From: Adam Birkett
Sent: 02 August 2019 12:27
To: planning
Subject: FW: app/3/2019/0476 Amendment, Land off Ribblesdale View Chatburn

From: Bloomer, David [<mailto:David.Bloomer@lancashire.gov.uk>]
Sent: 02 August 2019 11:55
To: Adam Birkett
Cc: LHS Customer Service
Subject: app/3/2019/0476 Amendment, Land off Ribblesdale View Chatburn

SJ Bialecki Limited Building Surveyors
Drawing no 6004(a)
Scale 1:50
Plot A Floor Layouts
Proposed Residential Development On Land At Ribblesdale View Chatburn

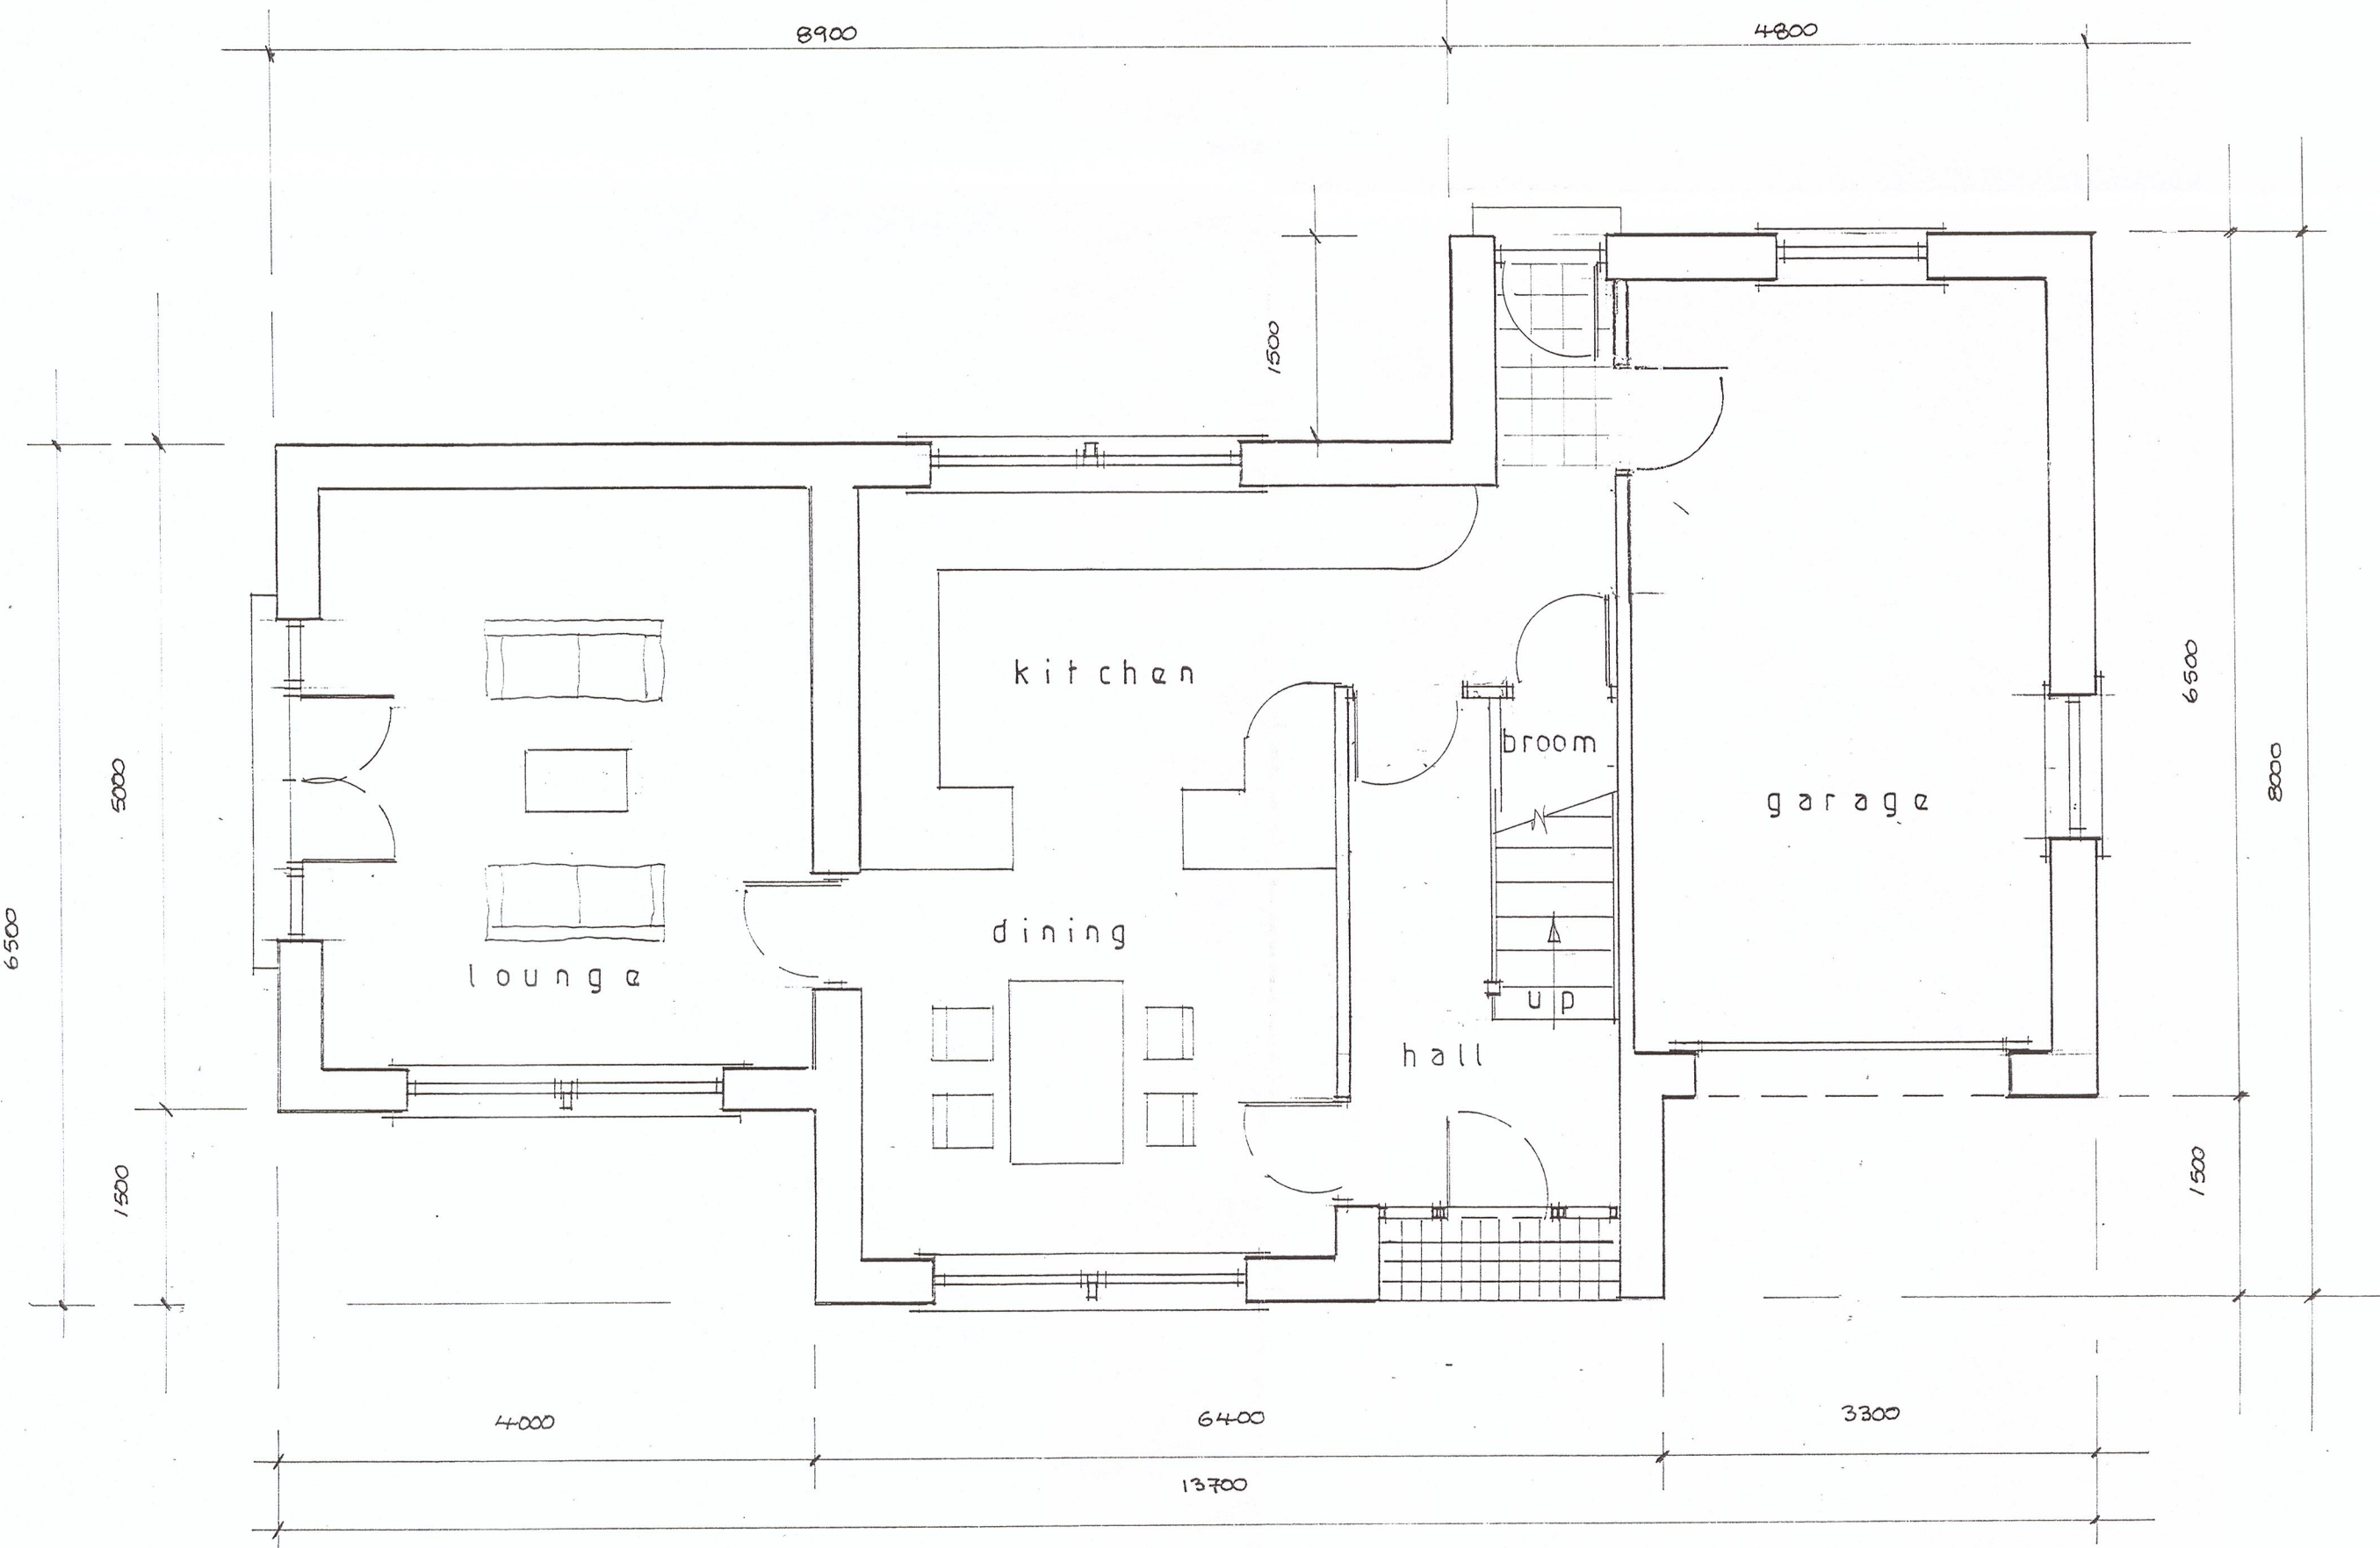
The proposed amendment sees the removal of the utility room from the rear of the garage as originally proposed resulting in a garage of sufficient dimensions to be regarded as an onsite parking space and I would therefore raise no objection to the proposal on highway grounds.
